MR & MRS D'ESTE-HOARE  
Letchmere Farmhouse  
Camp Road, Upper Heyford  
Bicester, Oxfordshire  
OX25 5LS

Mr Paul Feehily & Mr Andrew Lewis  
Development Management  
Cherwell District Council  
Bodicote  
Banbury  
OX15 4AA

**Planning Application Reference: 18/00825/HYBRID**

FIG 7 BUILDING HEIGHTS

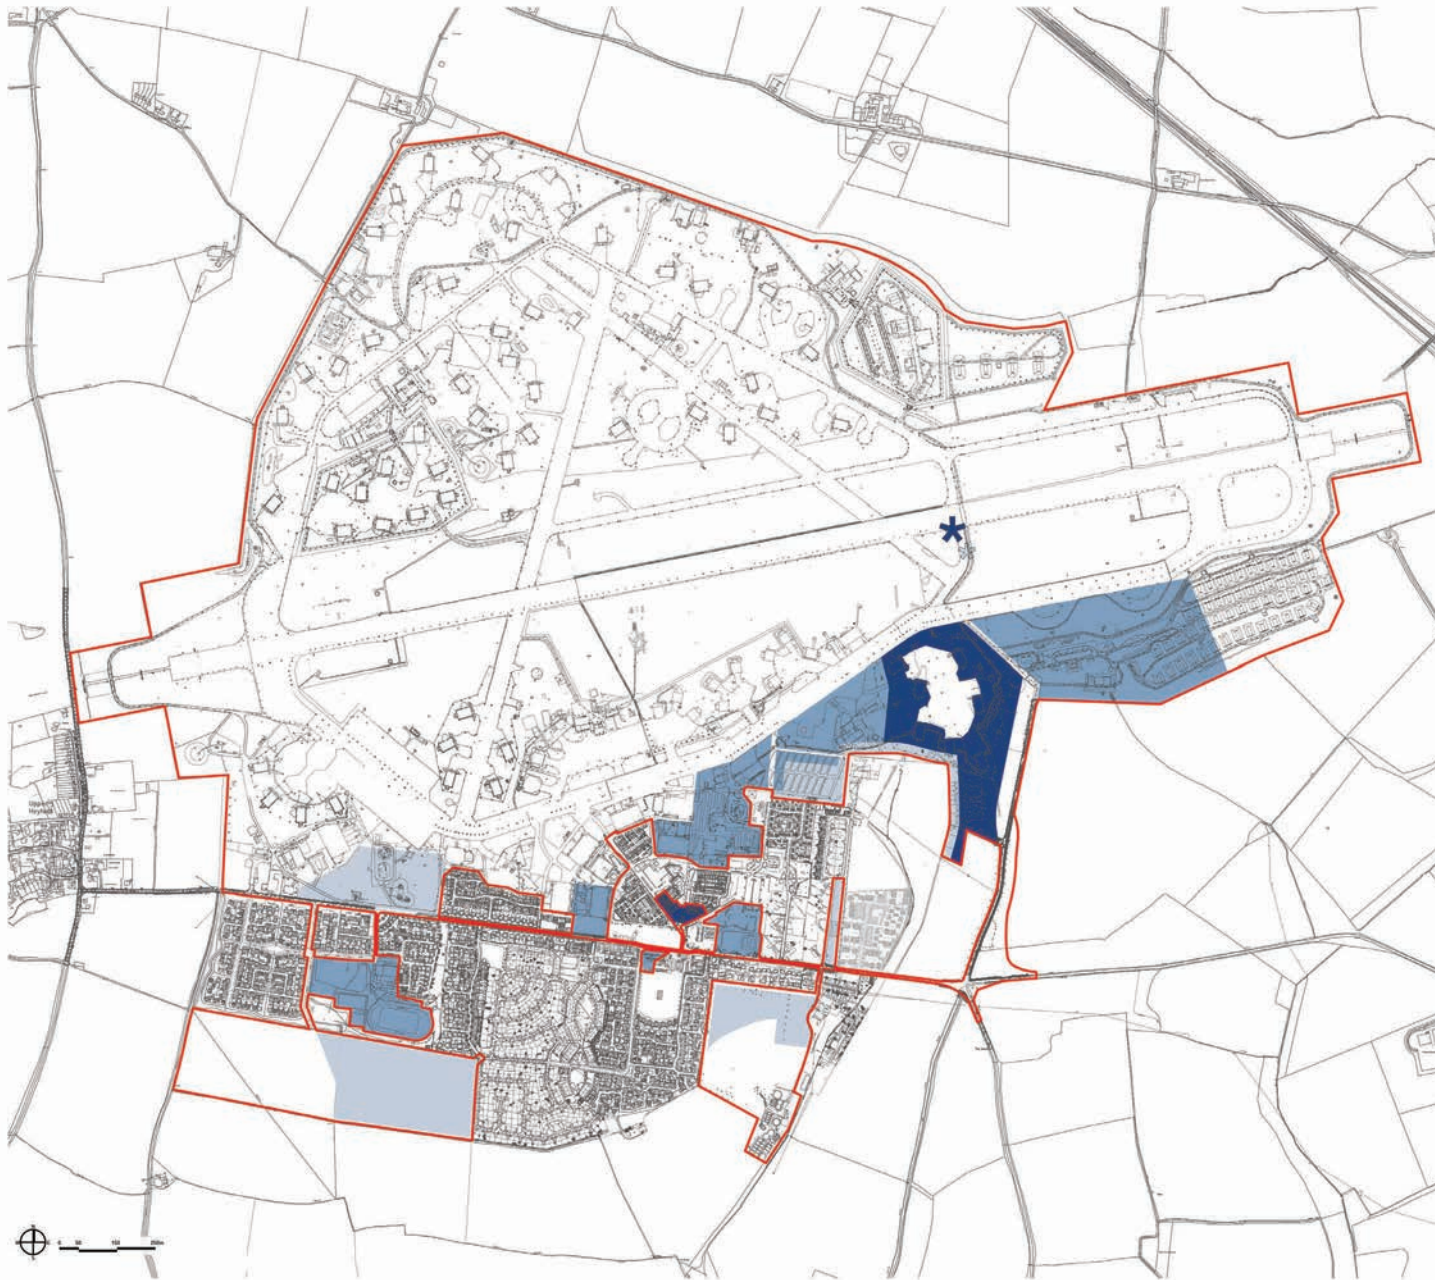
2. **Parcel 21:** We are pleased to see the old squadron headquarters in this Parcel being maintained, remaining single story and with the same footprint. However, we were led to believe at the public consultations that all buildings in this Parcel would be single story and therefore disappointed to see that the Masterplan shows buildings of 2 or 3 stories instead. Notwithstanding the heights of the properties are graduated as you move south to north, we object to buildings being 2 or 3 stories. If approval is to be considered, we request that:

- a. the mix and density of properties be reviewed
  - b. the heights of the properties be single storey and at the very most 2 stories only
  - c. any 2 storey properties are positioned in such a manner so that no properties back on to or overlook the existing properties within the Letchmere hamlet

3. **Height of proposed development in Parcel 23:** We support the creation of a digital/film economy within the Masterplan but object to the buildings with a height greater than the current height of the Hardened Aircraft Structures already in situ. Anything higher would be a visual eyesore and completely out of keeping with the rest of the buildings on Heyford Park.

FIGURE 9 PEDESTRIAN AND CYCLE CONNECTIONS

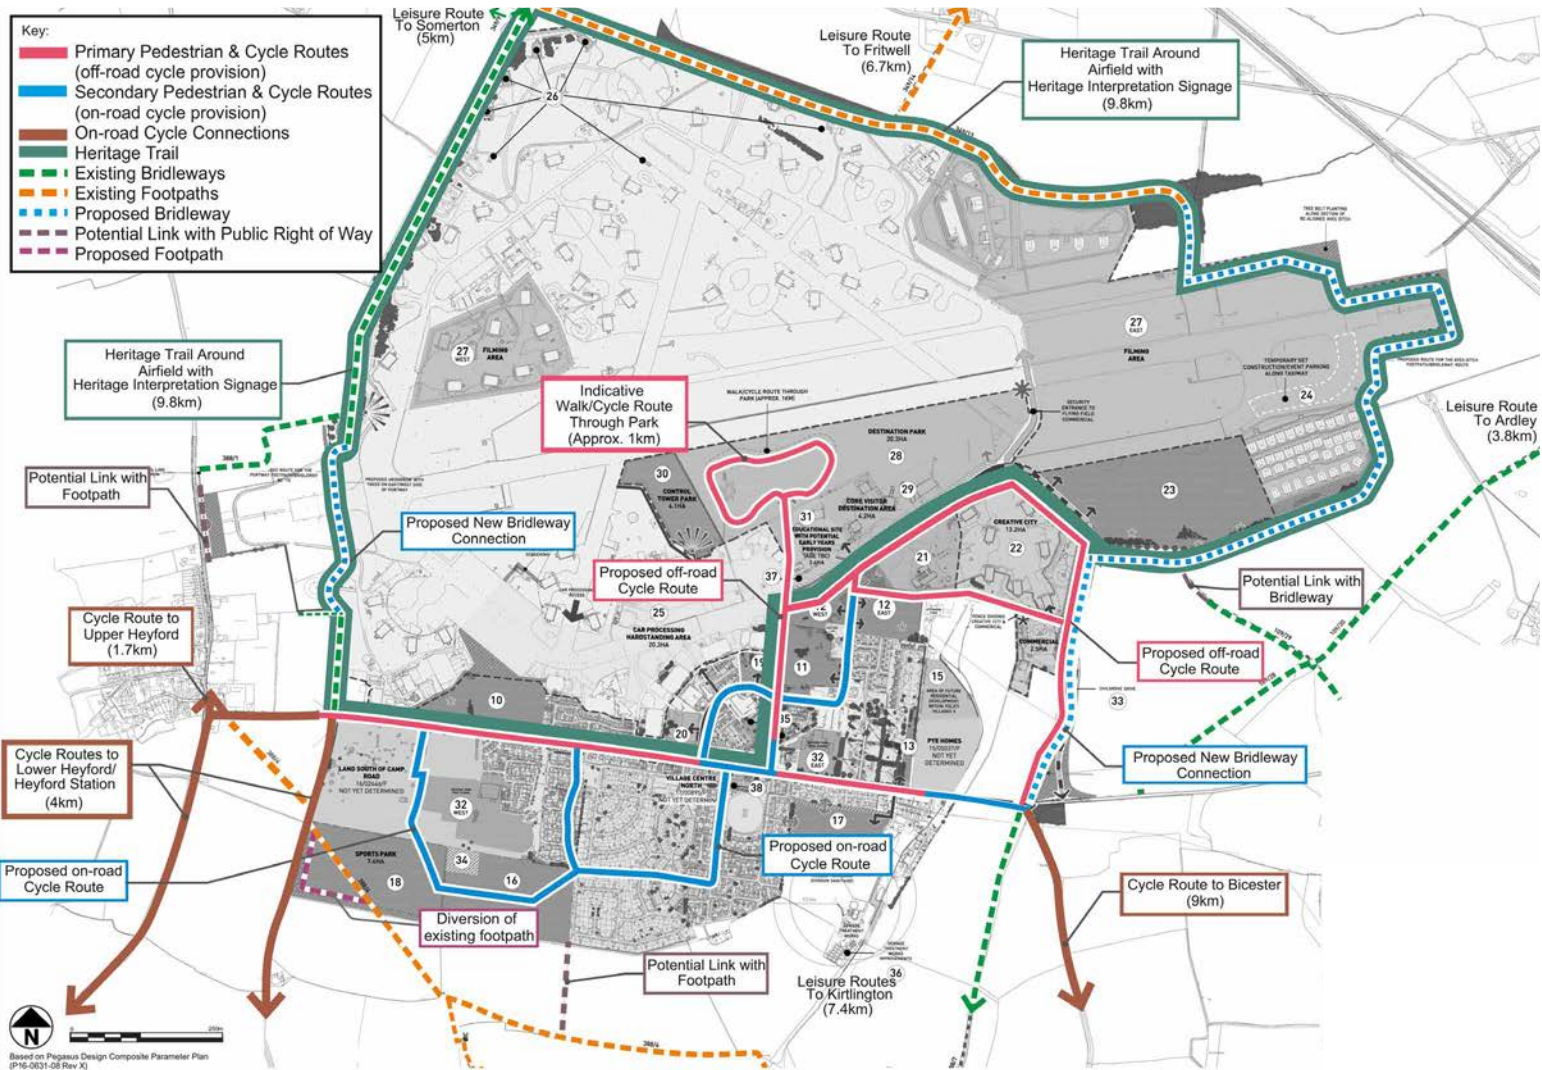
5. **Sufficient Access ways across Heyford Park:** the Masterplan doesn't in detail show pavements and how residents can walk or cycle around the new site.
